COUNCIL SUBMISSION TO MODIFIED STATE SIGNIFICANT DEVELOPMENT APPLICATION - SYDNEY OLYMPIC PARK HIGH SCHOOL (7 Burroway Road, Wentworth Point)

CITY OF PARRAMATTA COUNCIL SUBMISSION – PROPOSED SYDNEY OLYMPIC PARK HIGH SCHOOL - 7 BURROWAY ROAD, WENTWORTH POINT

SSDA
Proposed Elevations

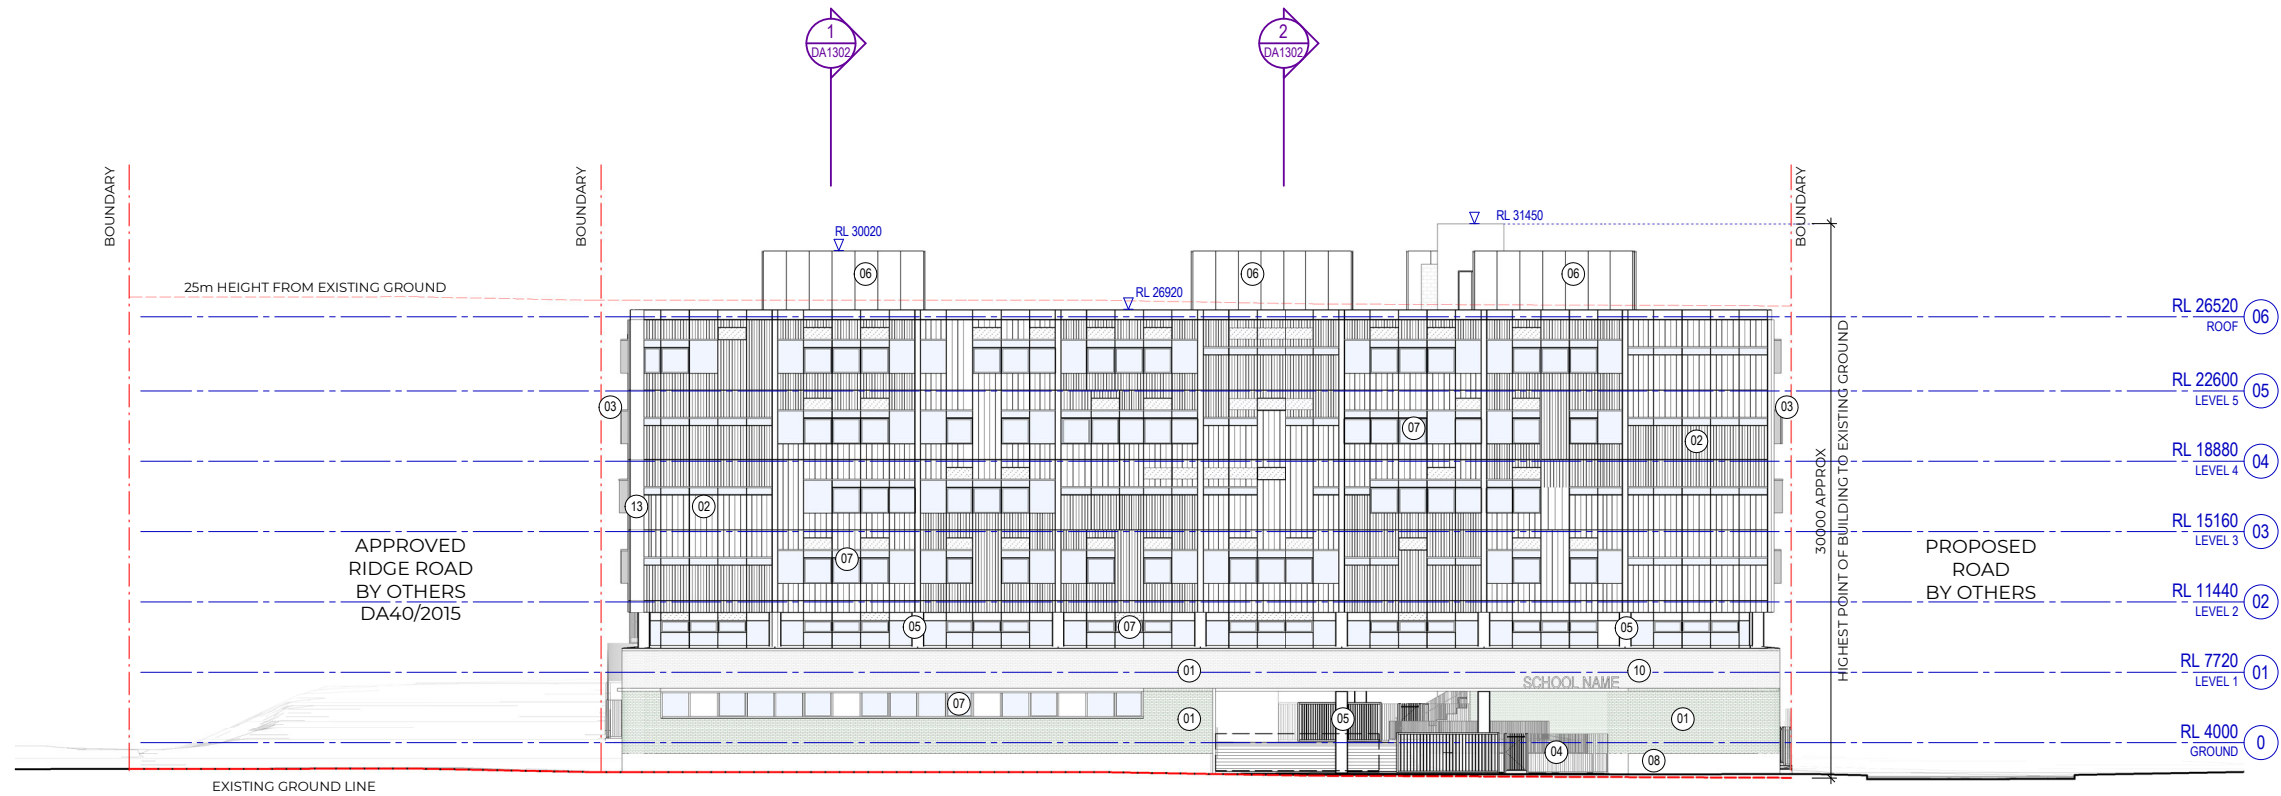
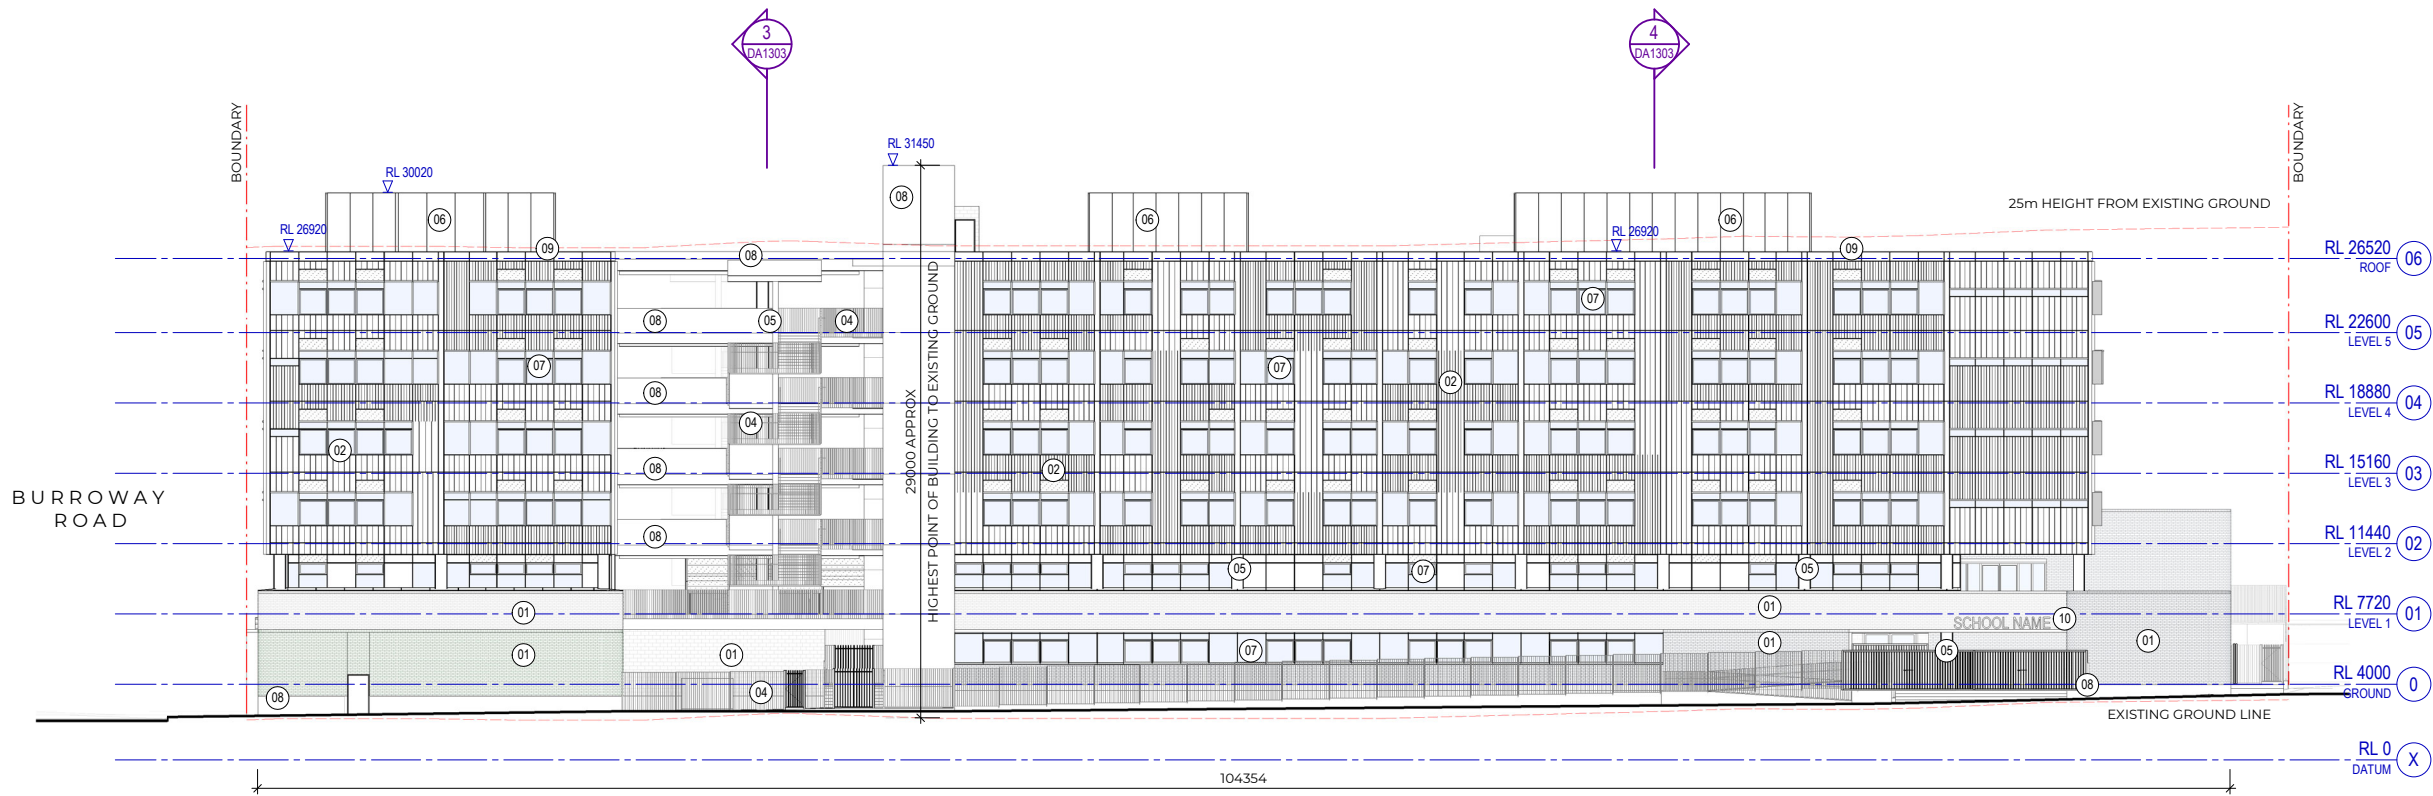
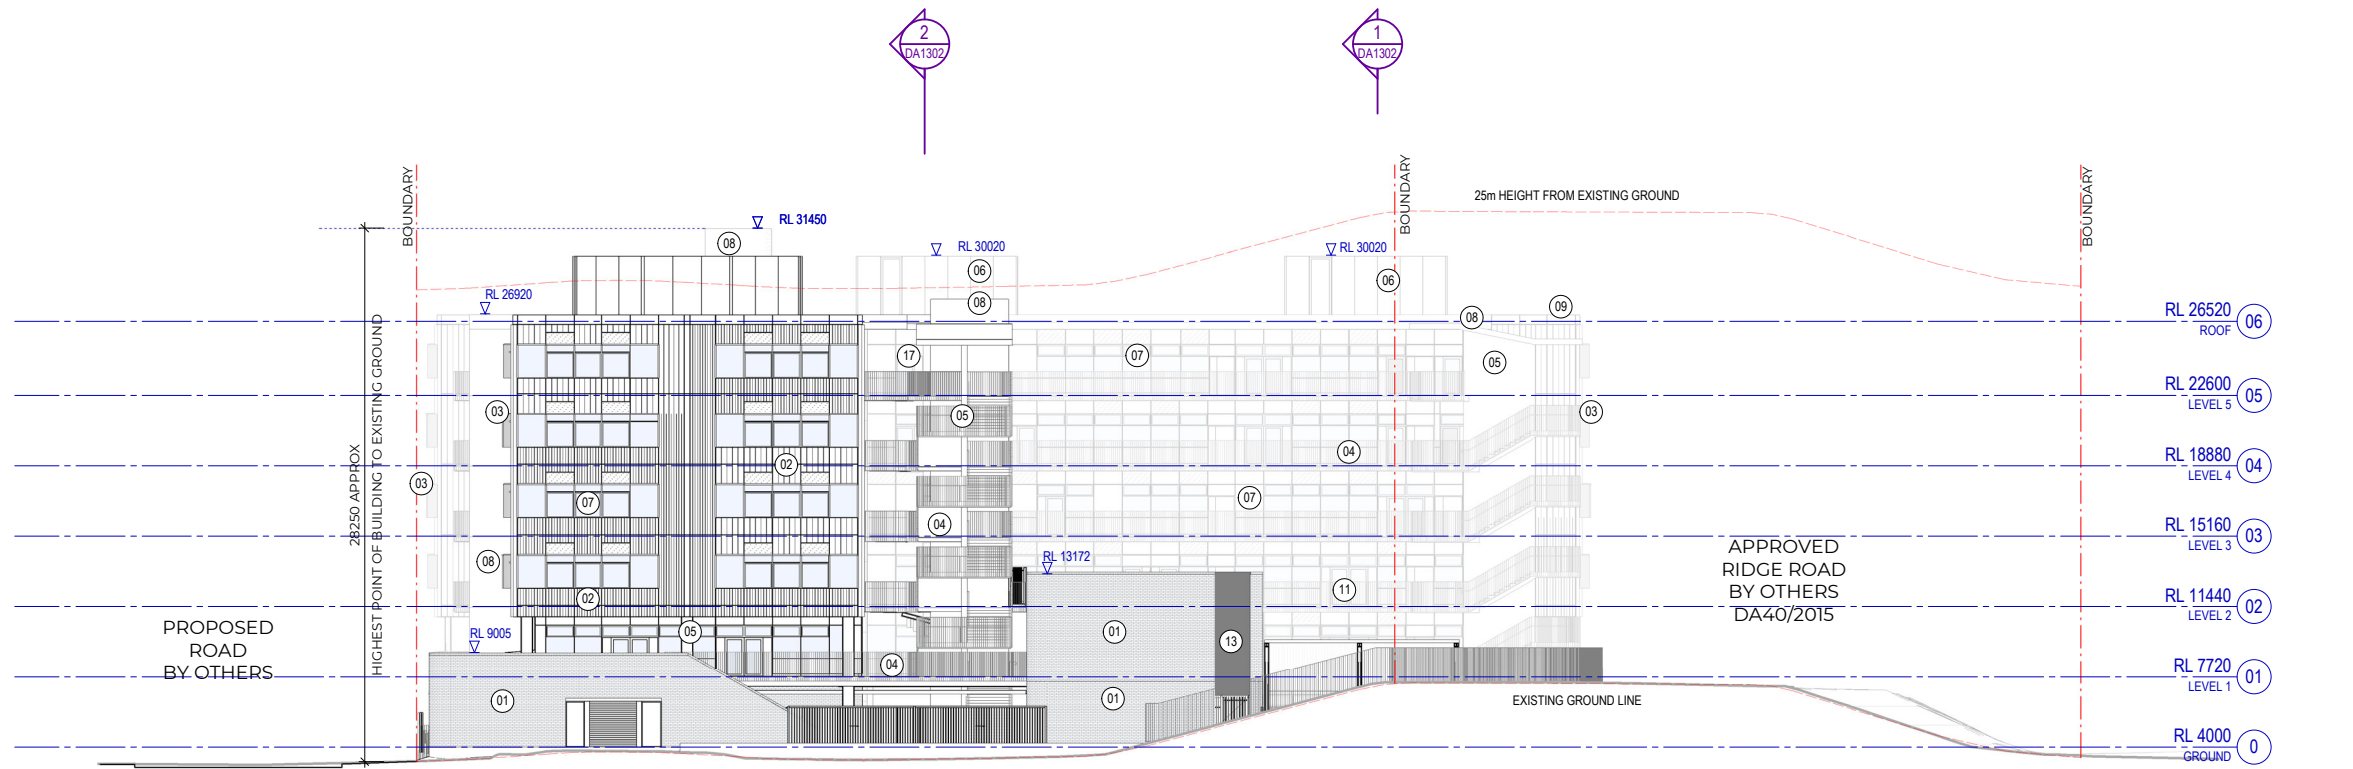
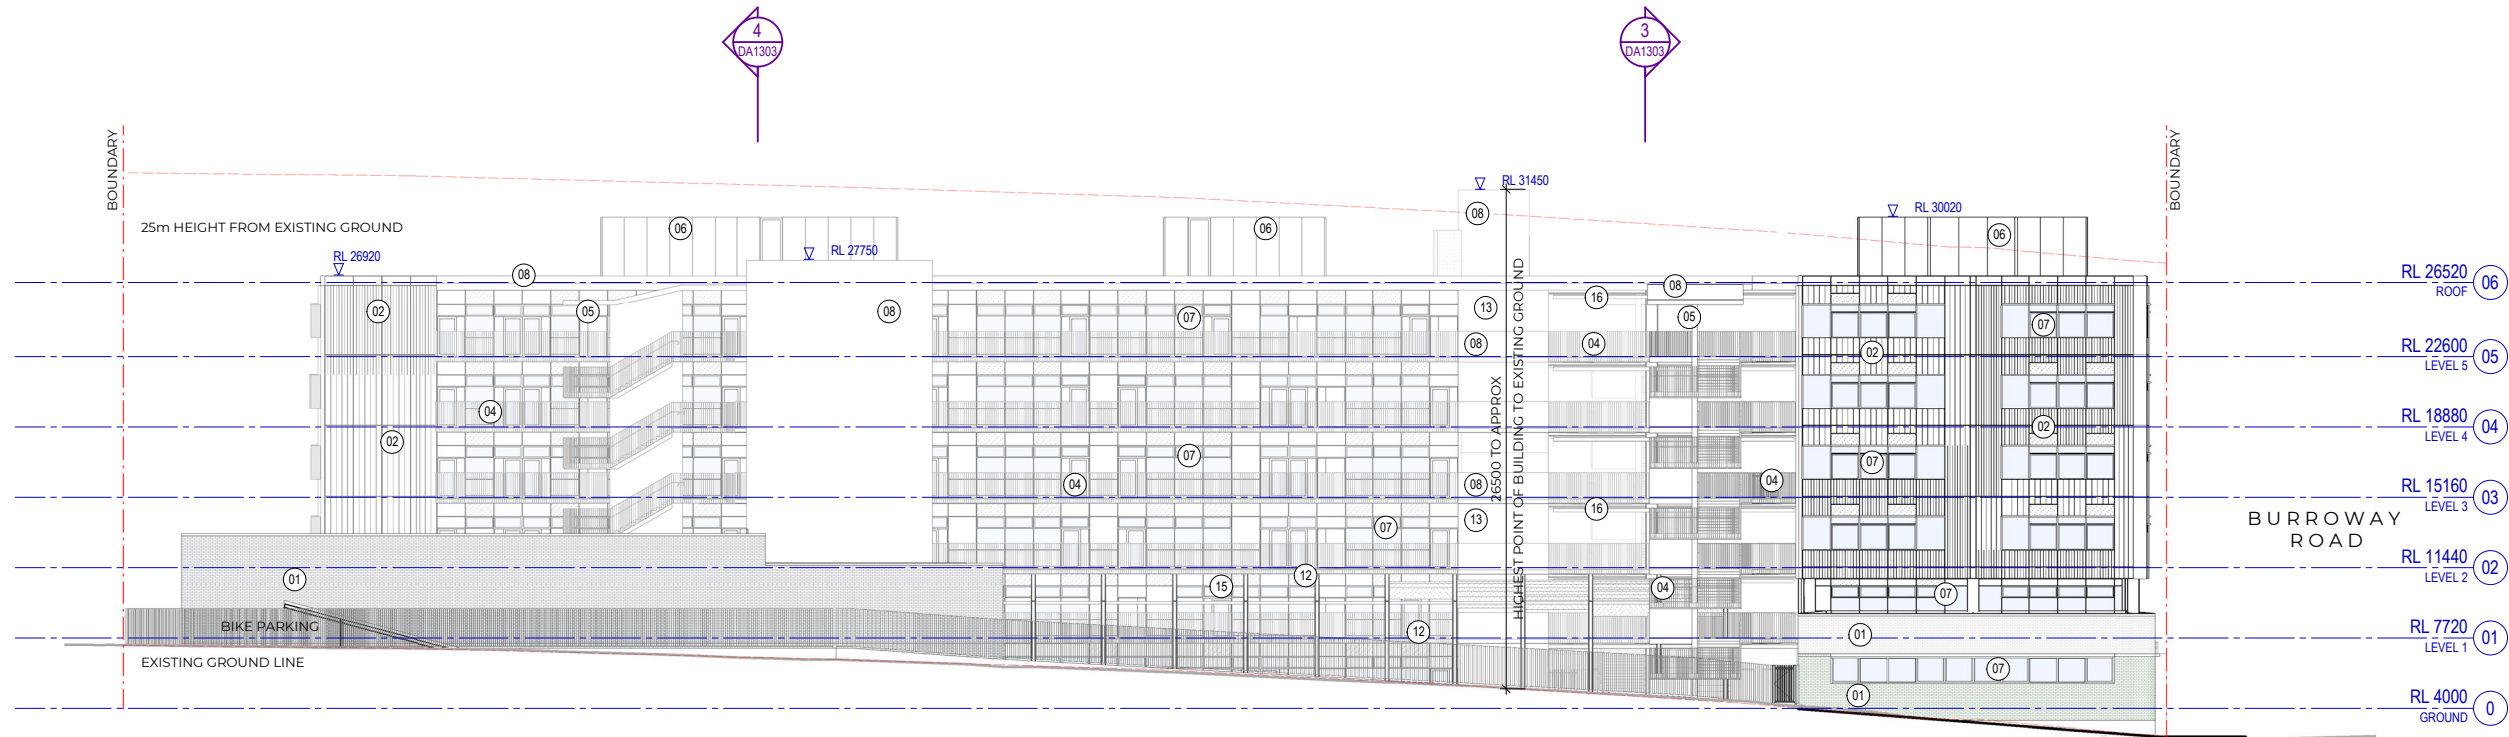
- Insufficient information has been provided to understand how the proposal integrates with Ridge Road and adjoining land. Sections and elevations are required indicating the approved levels of the adjoining land. Concerns are raised that the land levels have not been considered, which may result in poor amenity for students.
- It appears that the school will be at a similar level to the approved Ridge Road level, then will fall to approx. 1m below Ridge Road as it goes northbound. This could result in safety impacts on students from vehicular traffic, and visual amenity impacts.
- The school will be 2m higher than the eastern adjoining land and 1.5m to 2m higher than Burroway Road. The retaining walls and their impacts have not been adequately detailed.
